FINAL DEVELOPMENT PLAN

JUDGE ORR ROAD RV PARK AND STORAGE

File number: PPR-16-040

SHEET NO.  
**DP1**  
1 OF 7 SHEETS

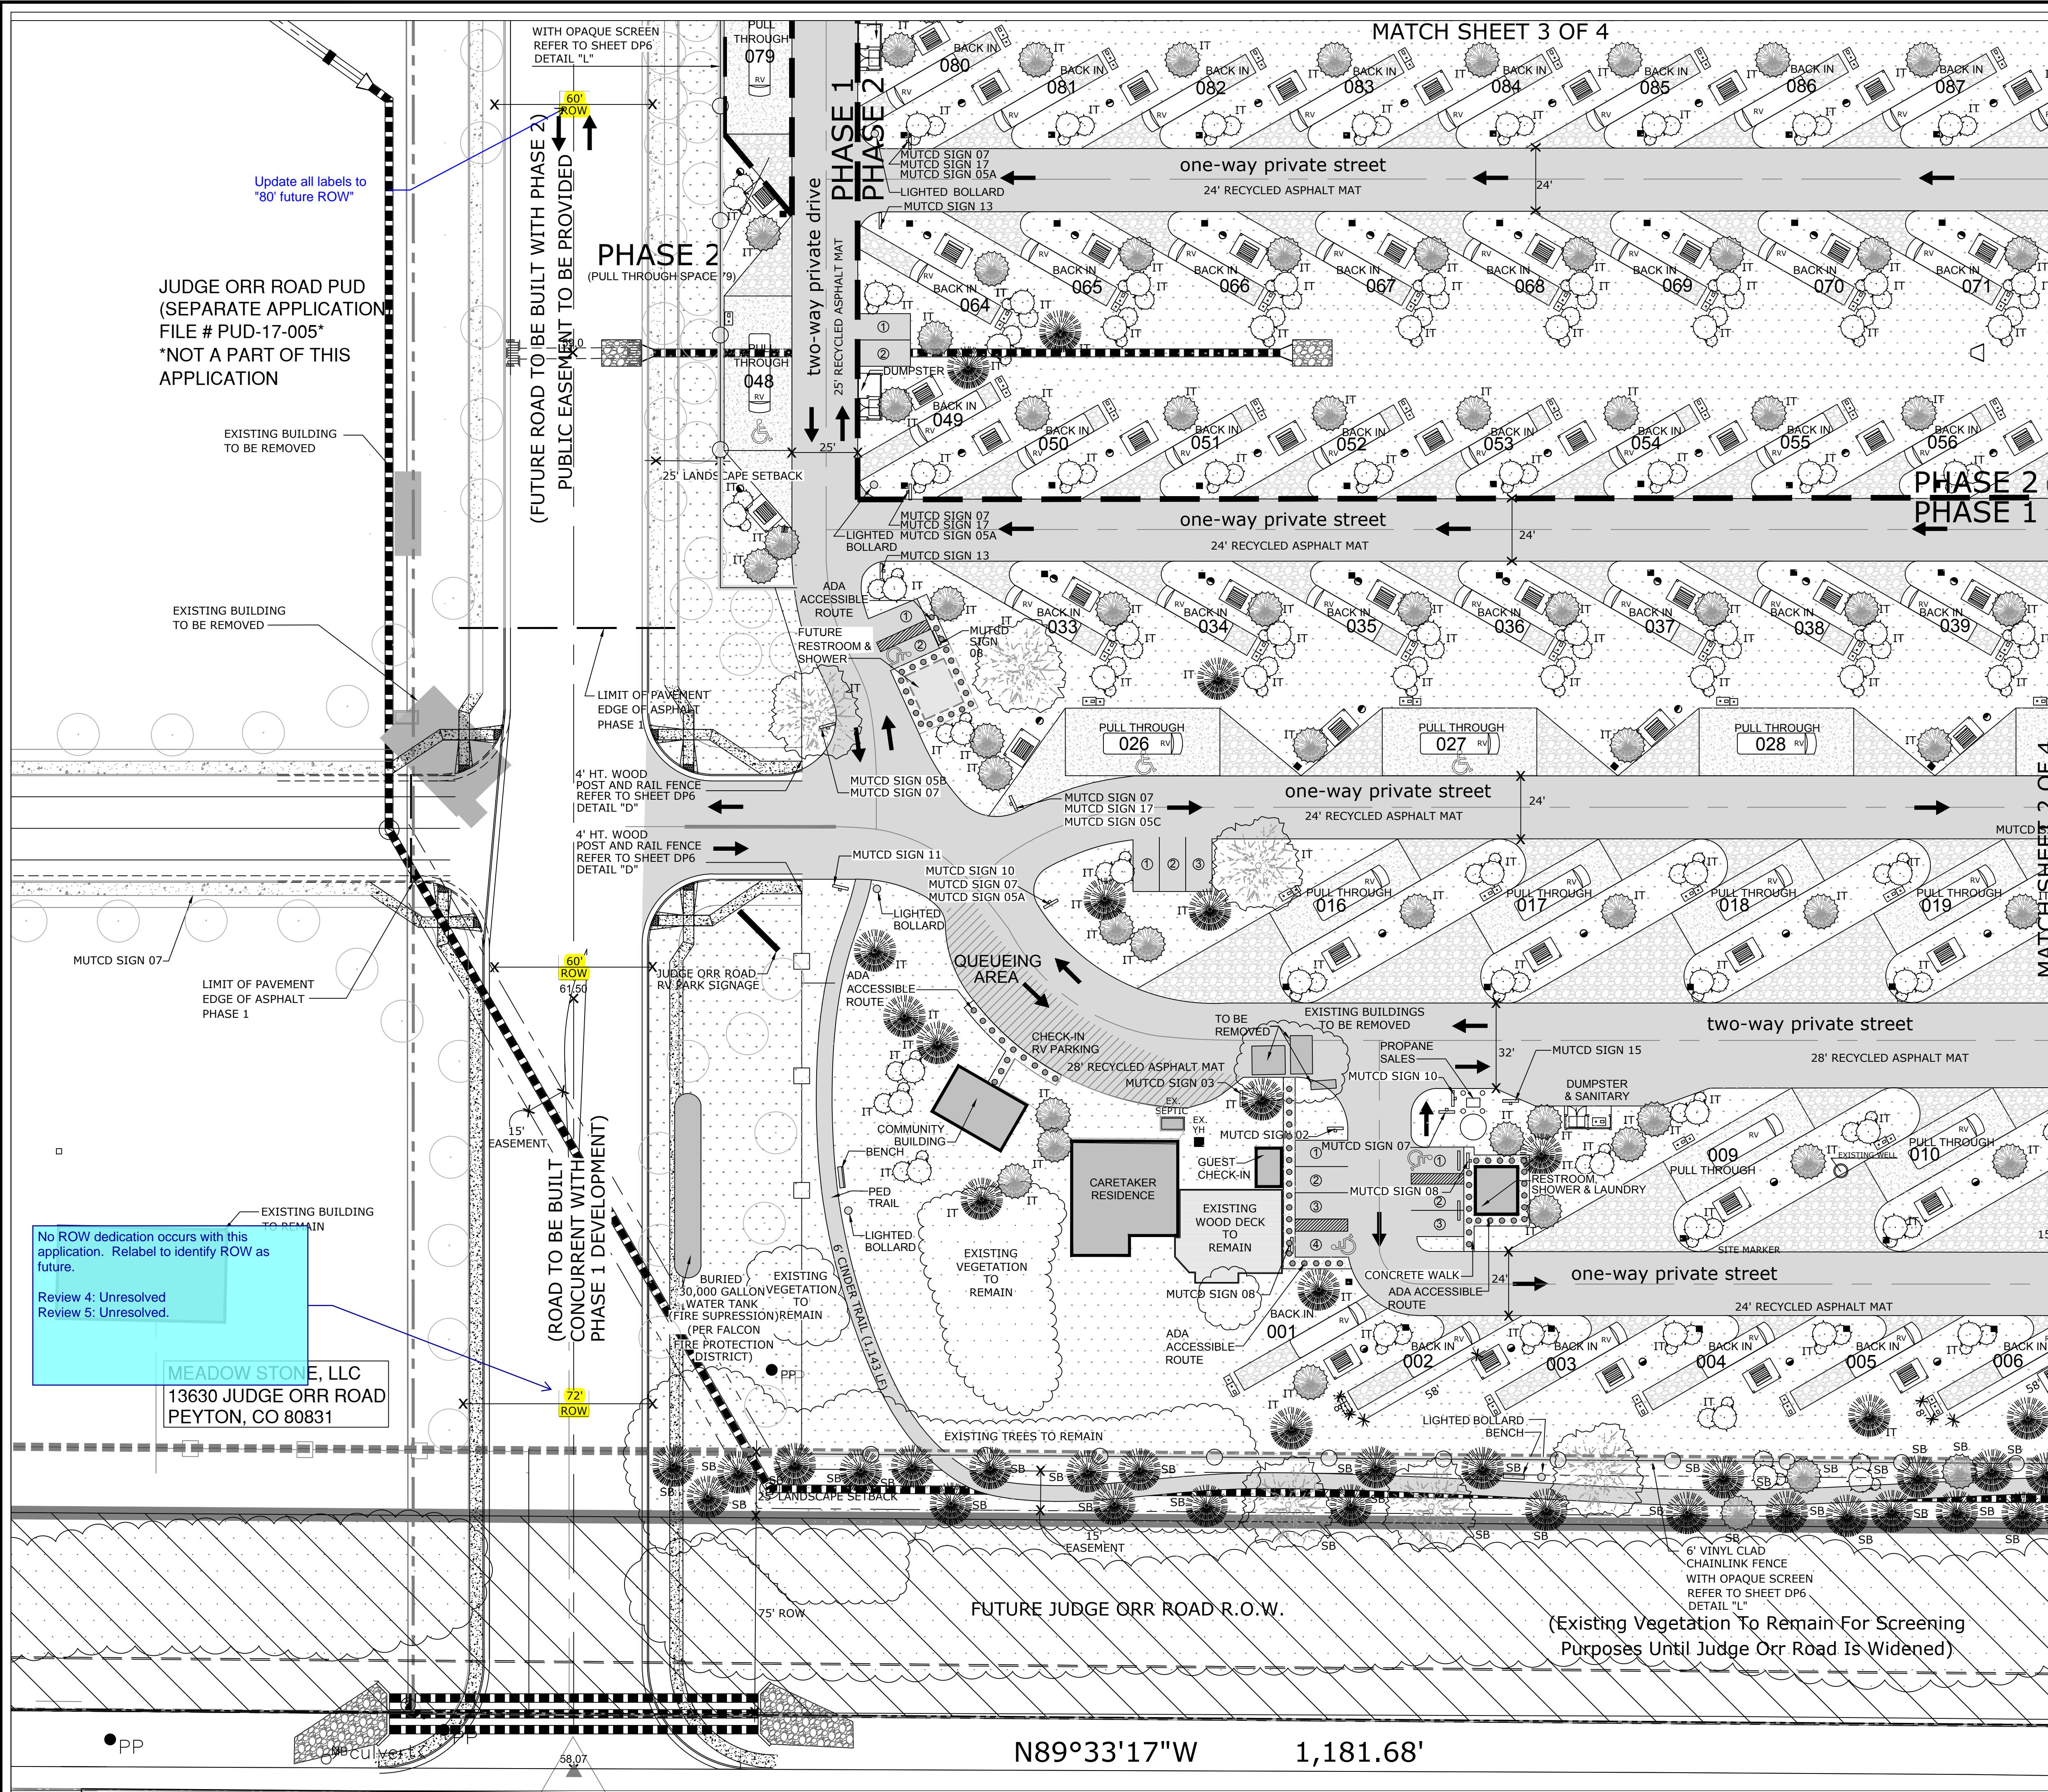
outside storage is to be 100% screened from view. Only a chain link fence is shown.

Make sure the intersection spacing meets the criteria for the TIS's recommended roadway classification.

These are RV's and not dwelling units.

LDC Section 4.2.5.C.6 requires ROW 25'

remove shading to make drawing clear.

It is difficult to see the phasing schedule. Please add a sheet that includes just the phasing with a chart outlining the units/acreage

Please add in a chart with the phasing data as well.

No parking detail has been provided. No parking table has been provided. Please add the parking detail and chart to demonstrate there is adequate parking on site for the proposed uses and number of spaces.

SHEET NO. **DP3** 3 OF 7 SHEETS

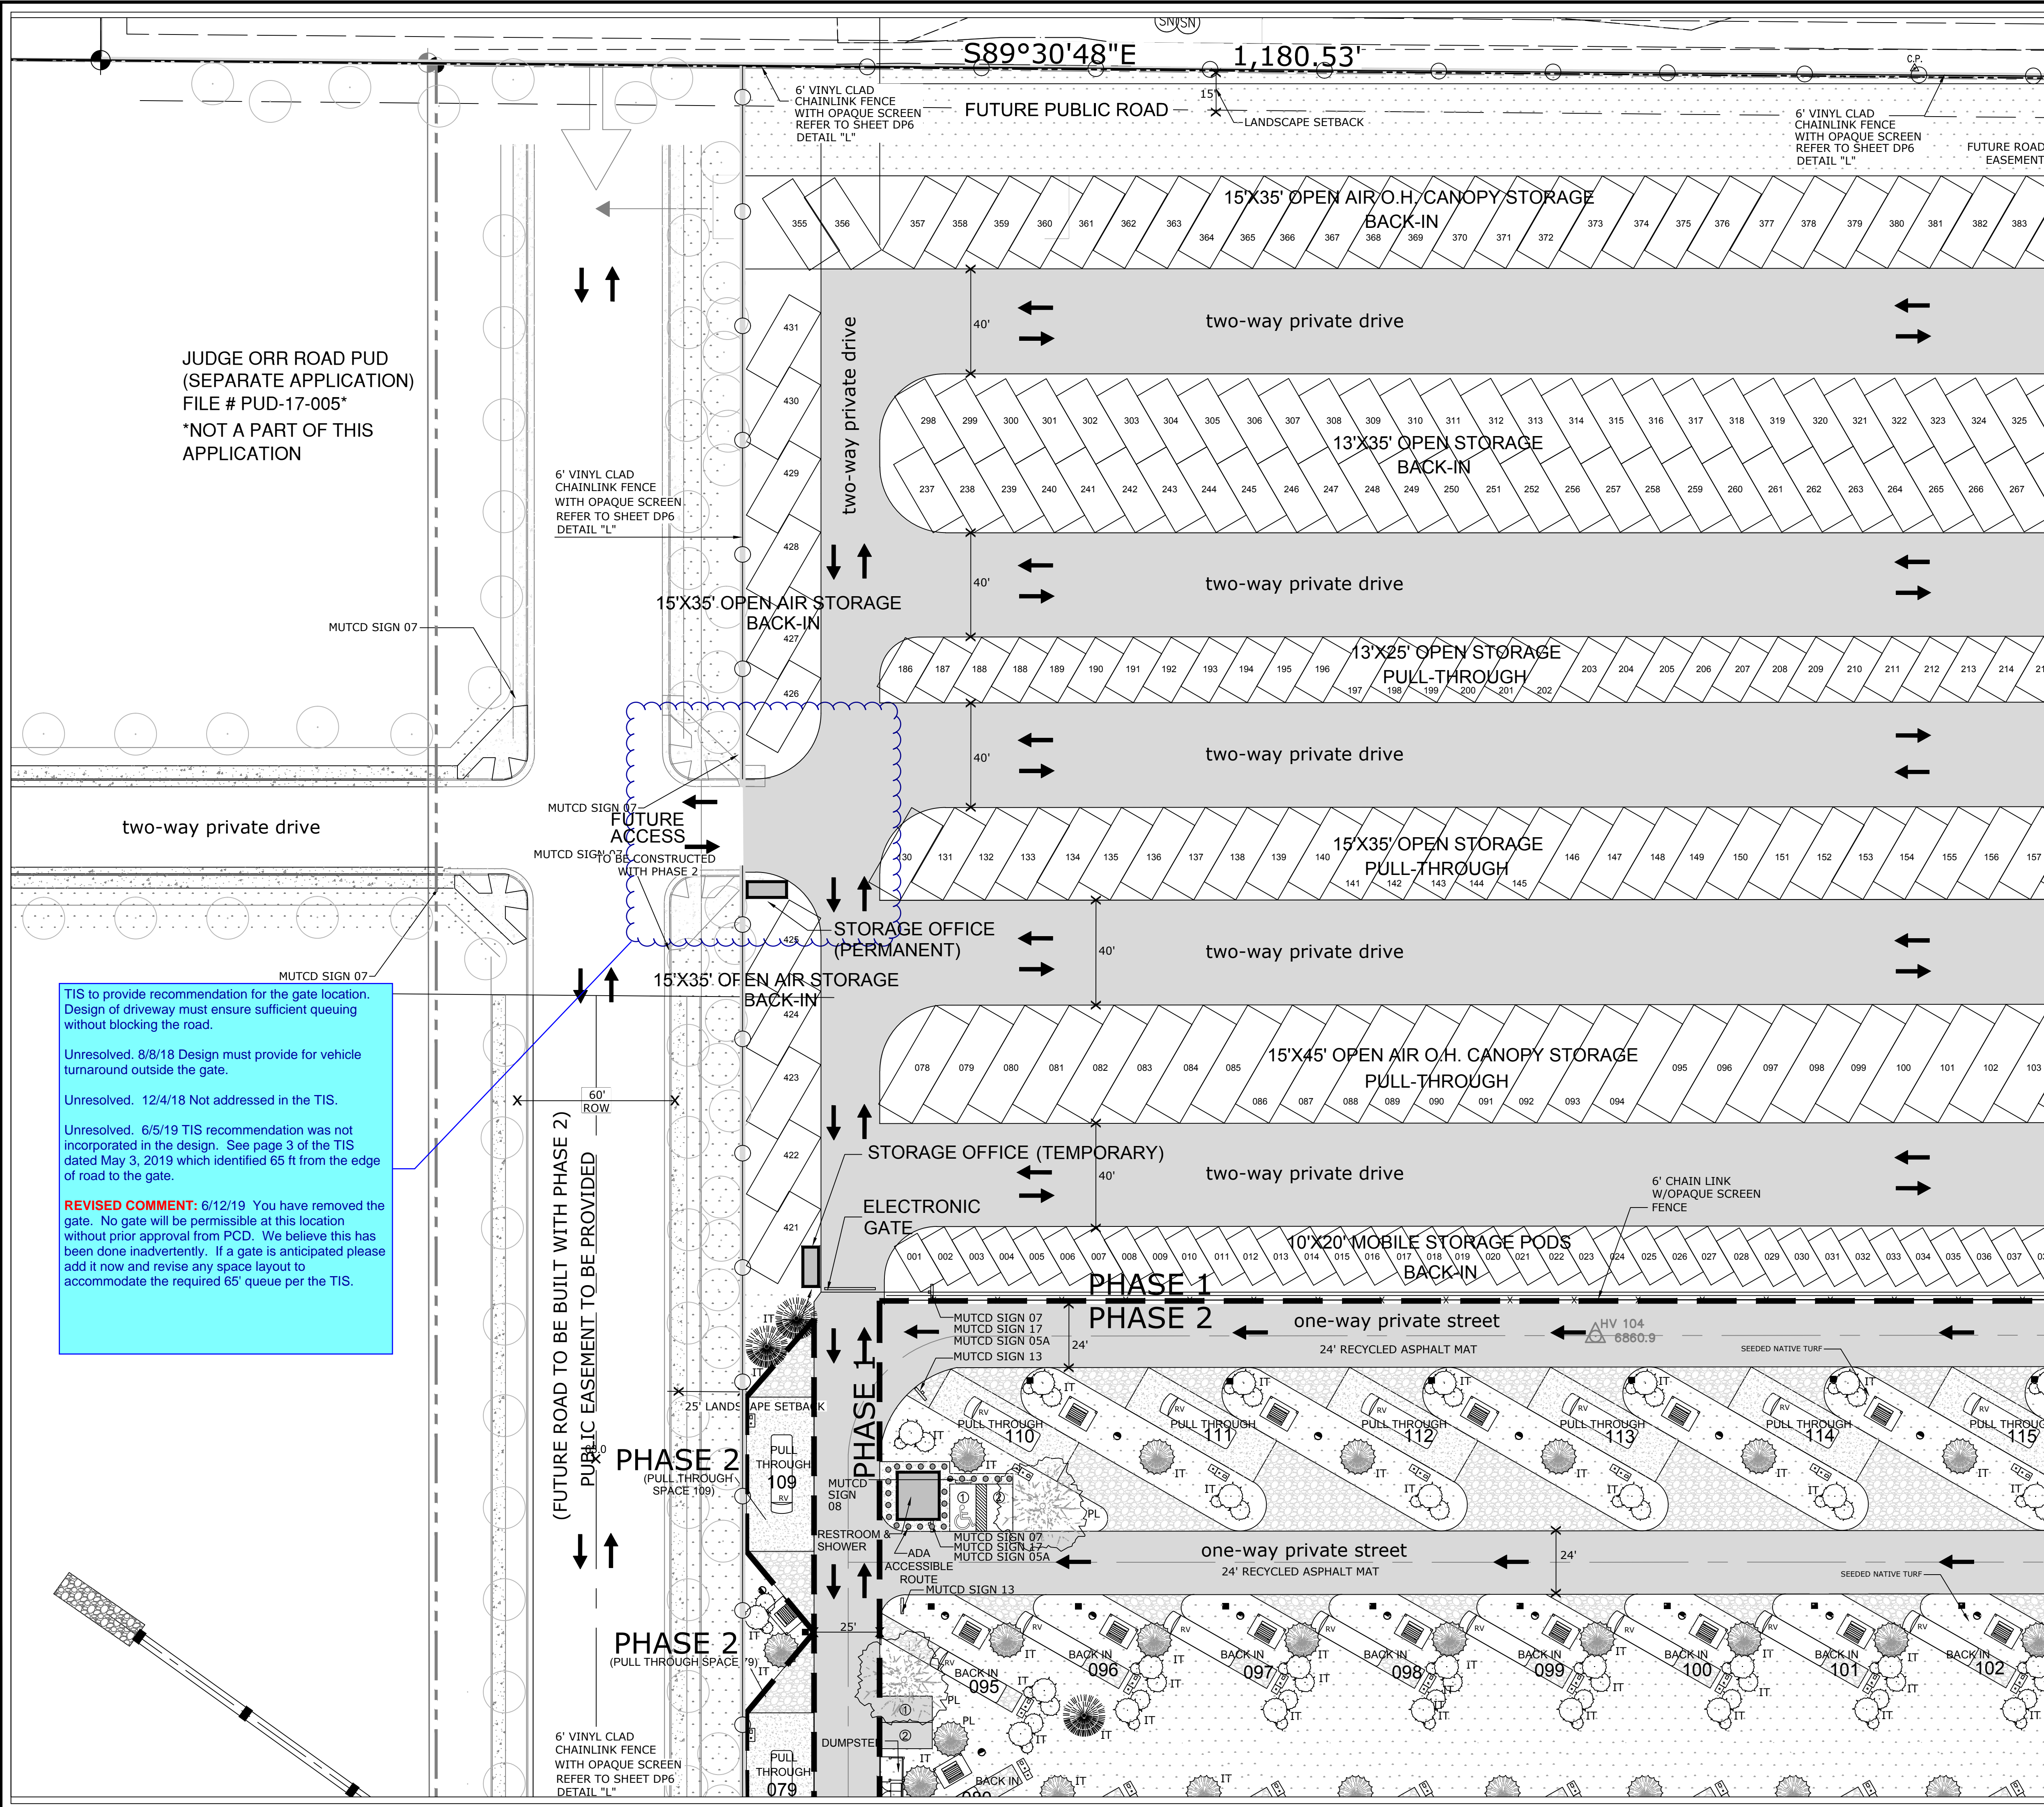
Include the geometry showing the anticipated ROW if the applicant intends to request that the County accept this road in the future. Can also be submitted as a separate exhibit. The main intent is to make sure there are no potential issues with the future subdivision and ROW dedication.

Provide street construction plans for the roadway and roundabout

Label. Unclear what these represent.

This access configuration does not seem to provide sufficient turn movements for RV's going into the roundabout. The Traffic Study shall provide Autoturn exhibits.

Additionally, fastest path influence is likely longer than the current configuration. Coordinate with the TIS regarding the roundabout design.

Also consider access spacings so that there are no conflicts with any future ROW dedication

Revise. The Wisconsin DOT Facilities Development Manual (FDM), FDM 11-26 section is referenced where County criteria and the NCHRP Report 672 (Roundabouts: An Informational Guide) are lacking in detailed criteria. Roundabout design procedures and criteria in the FDM, including design procedures, details, signing and striping recommendations and lines of sight, should be utilized to the extent practicable.
<http://wisconsin.gov/Pages/doing-business/consultants/cnsl-rsces/design.aspx> Regarding roundabout lighting, reference <http://wisconsin.gov/Pages/doing-business/local-government/traffic-operations/manuals-and-standards/tgm/11.aspx> / <http://wisconsin.gov/dtsdManuals/traffic-operations/manuals-and-standards/teops/11-04.pdf> for guidance. Please discuss any conflicting or redundant criteria with Staff.

provide a description. Is this a setback or easement?

What is this?

The spaces do not meet the setback requirements of the
File number: PPR-16-040
